Planning - Case Comments

Project Number: PR-2022-004457

Project Name: Quivira Estates

Final Plat

ENGINEER'S SEAL DAVID SOULE P.E. #14522	QUIVIRA ESTATES SITE PLAN FOR BUILDING PERMIT	DRAWN BY WCWJ DATE 8-21-21 2102059-LAYOUT-8-06-20
	 Rio Grande Engineering 1606 CENTRAL AVENUE SE SUITE 201 ALBUQUERQUE, NM 87106 (505) 872-0999	SHEET # 1 JOB # 2102059

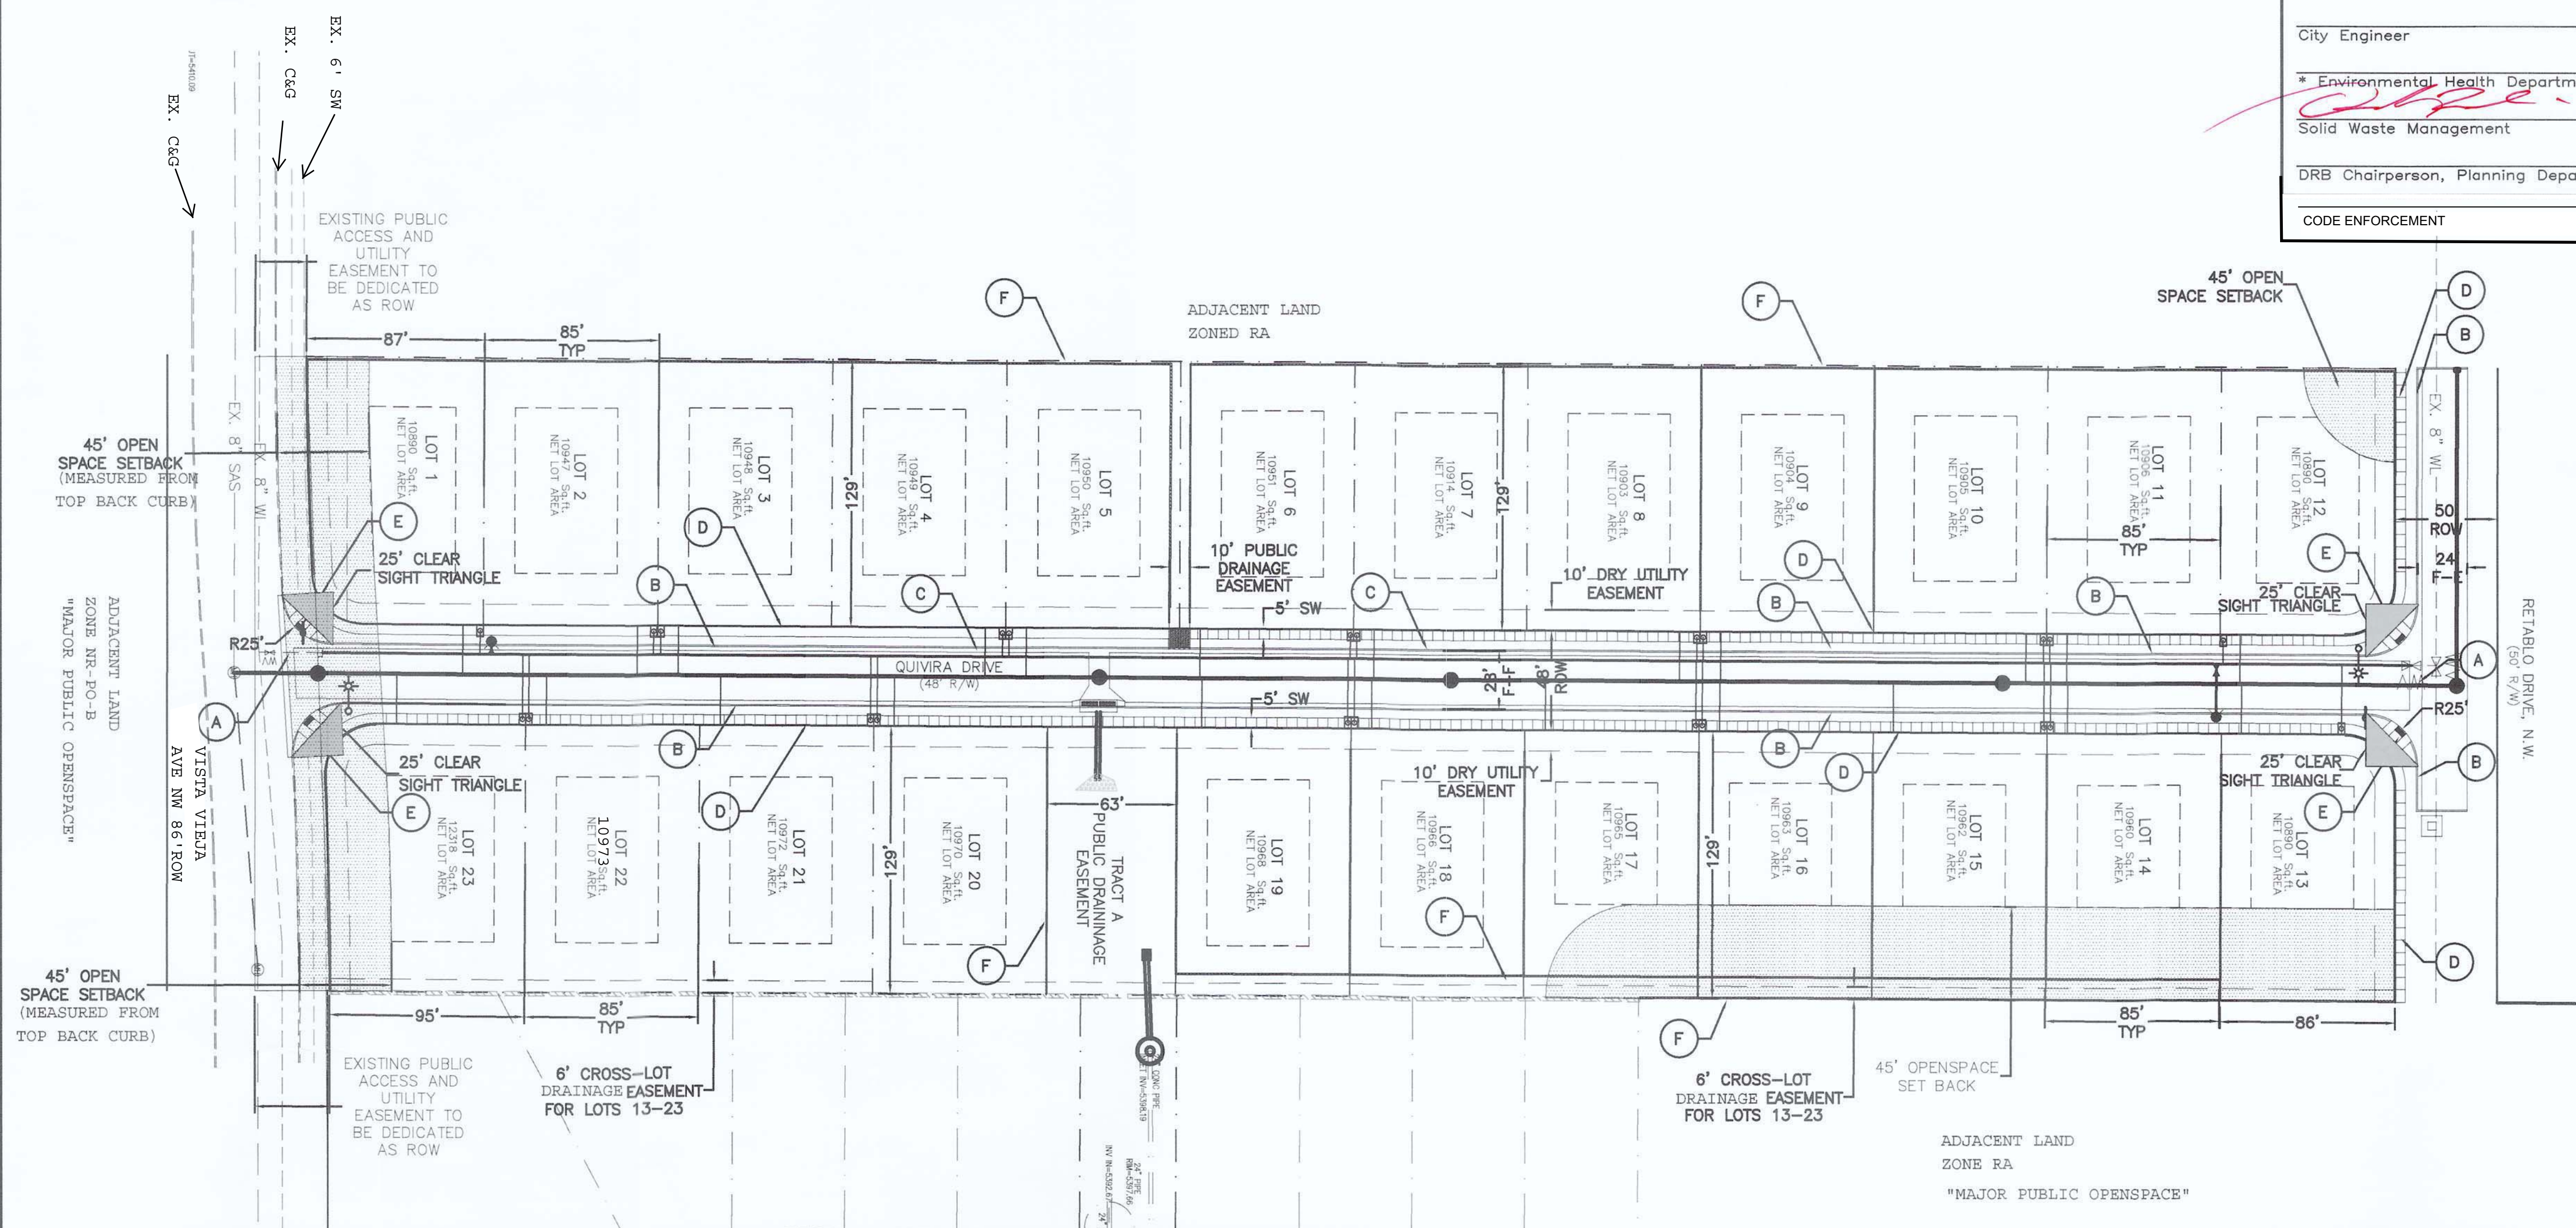
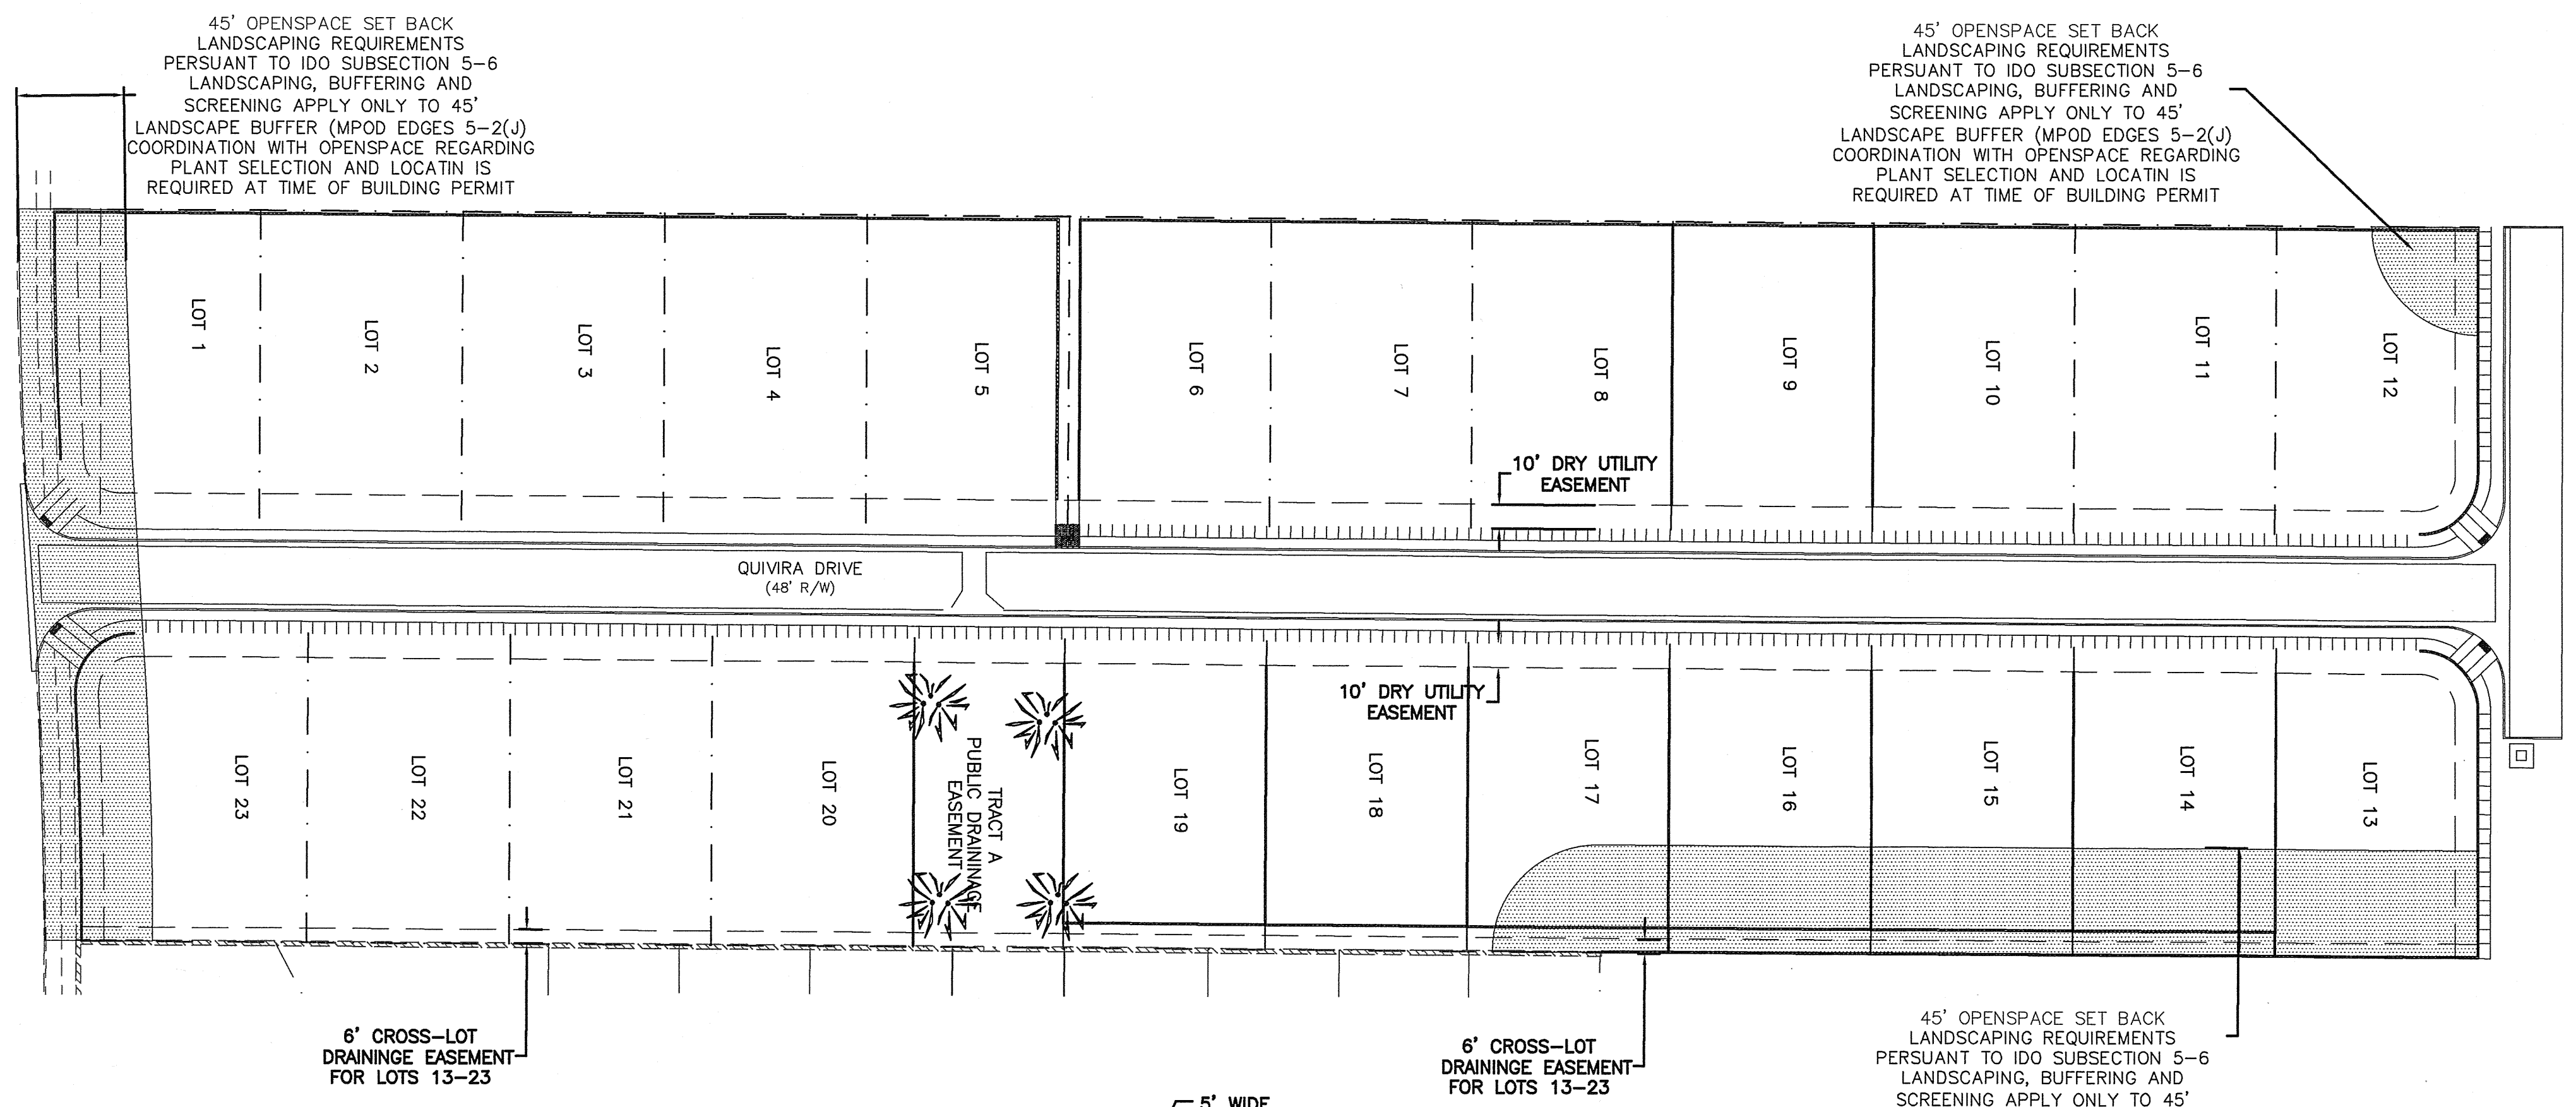
1. Property is zoned RA and is located within and Northwest Mesa Escarpment, VPO-2. Must meet Dimensional standards as per IDO 5-1(C), Table 5-1-1; CPO-13, per 3-4(N)(3), as applicable. Development must meet all other applicable standards in these overlay zones, as well.
2. Note on Sheet #1 indicates “All Future Development governed by 2019 IDO regulations.” I believe this should be updated to 2023, but will defer to Planning for consideration/review of this note.
3. Code Enforcement defers to Parks regarding requirements for areas shown as within a 45 foot Open Space Buffer areas, as per IDO 5-2(J)(2)(a)(1). Landscape/use within these areas is subject to approval of the Open Space Superintendent. Perhaps a note as such should be added to the Plat.
4. CE has no further comments or objections at this time.

- Planning defers to Parks and Recreation to clarify the note regarding the 45- foot setback at the northeast corner of the site that the area can include no structures except for view fencing.
